PLANNING APPLICATION FOR THE EXPANSION OF A MATERIALS RECOVERY FACILITY AT CAPPOGUE AND DUNSINK, BALLYCOOLIN ROAD, DUBLIN 11.

Response to Request for Further Information

Abstract: This report contains the response to a Request for Further Information (RFI) in connection with planning case number ABP-315257-22 for development at Cappogue and Dunsink, Dublin 11.

O:\ACAD\2021\P21-150\P21-150-0305-0003

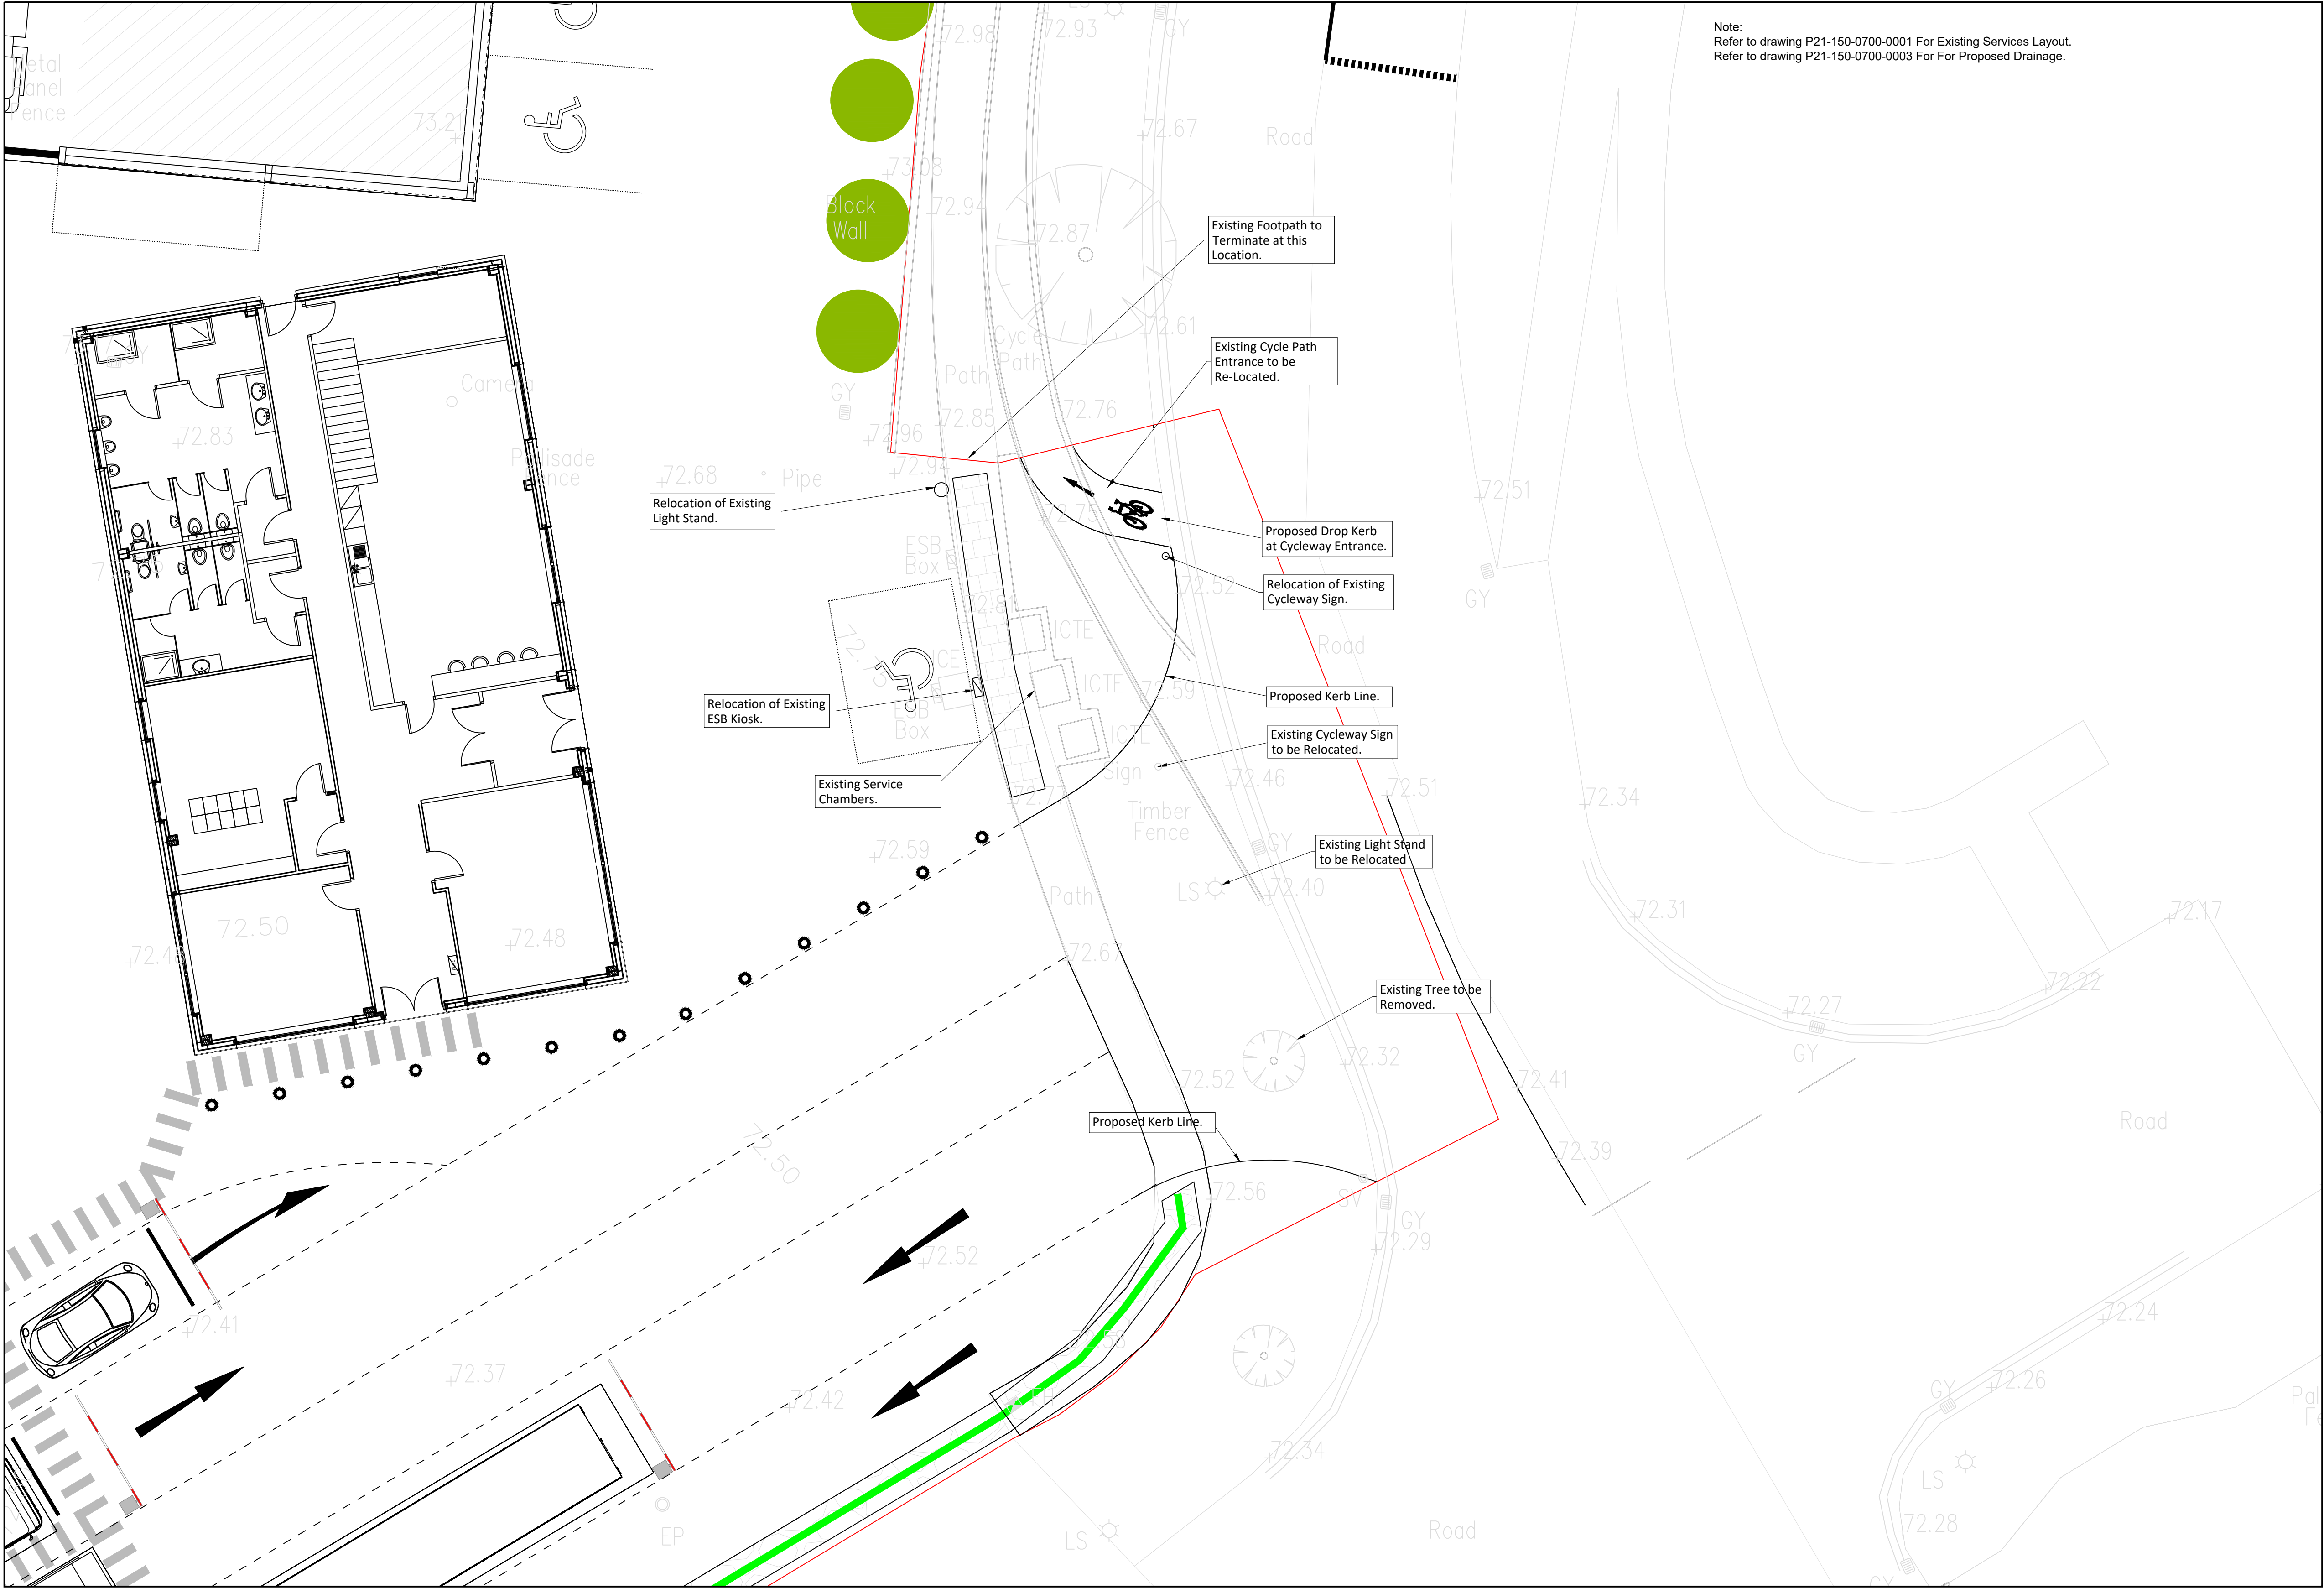
Revised detailed plans should also include how the new access and crossover of the existing footpath and cycle track would occur. Clarify if these crossover works are outside land in your ownership and submit revised site boundary plans as necessary and any associated permissions.

In consultation and in agreement with Fingal County Council, the Applicant has revised the red line boundary to extend the red line boundary within the original planning drawings at Entrance 2. The red line boundary now extends to the middle of the road at Entrance 2. Refer to Planning Drawings P21-150-0200-0001 Rev B and P21-150-0305-0003 Rev A.

Entrance 2 will cross over the existing footpath and cycle track. The cycle track will require minor realignment to accommodate the new kerb line for the entrance. The beginning of the cycle track will be moved approximately 4m north. The existing sign will be relocated as part of the cycle track realignment.

The existing footpath will remain largely unaltered. No realignment will occur, however drop kerbs will be emplaced at either side of the new entrance. New signage will be installed to inform incoming and outgoing traffic of pedestrian traffic.
